Mountain View Electric Association, Inc. (MVEA) has these comments about the following:

Project Name: High Plains, Filing #1

Project Number: SP 183

HIGH PLAINS FILING NO. 1		DESIGNED BY: DLM	DRAWN BY: DBM
PRELIMINARY PLAN		SCALE: 1"=100'	DATE: 11/26/18
		JOB NUMBER: 17-135	SHEET: 1 OF 1

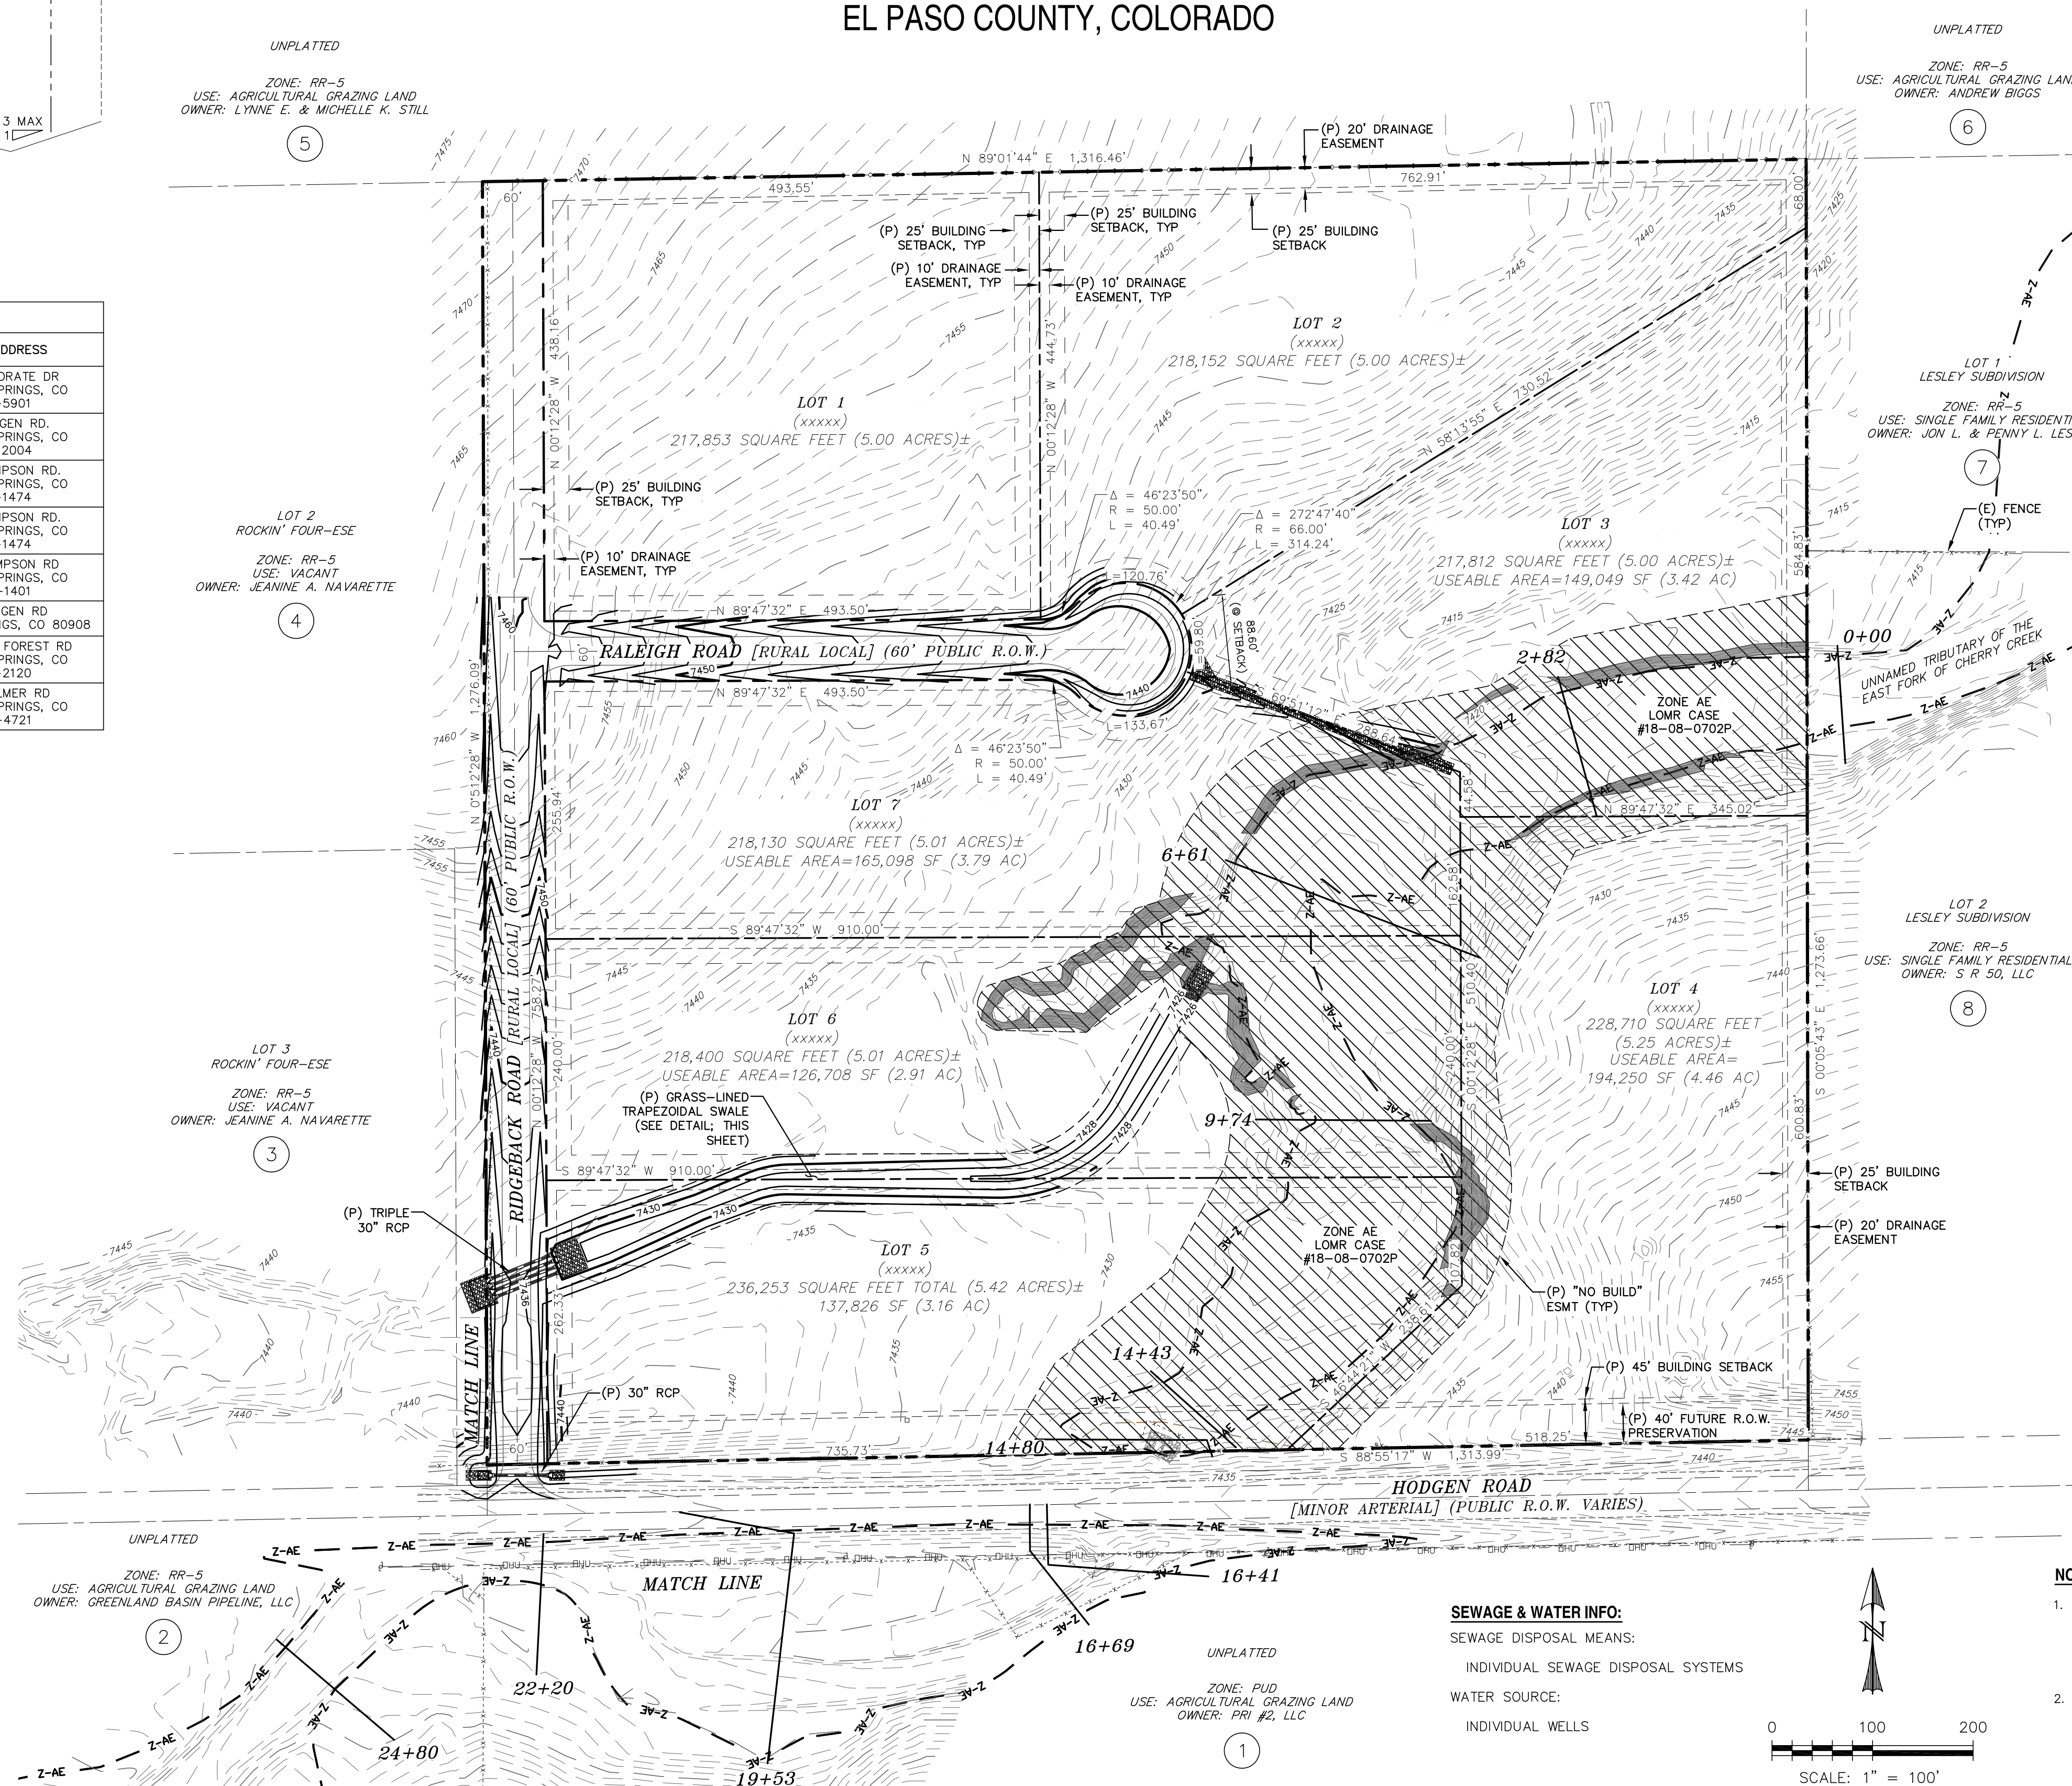
MVEA requests a ten (10) foot front and side lot line utility easement along with a twenty (20) foot exterior easement on plat. MVEA also requests platting of existing MVEA facilities with easement on the plat. Additional easements may be required once a review of civil drawings with grading and erosion plan is provided to MVEA.
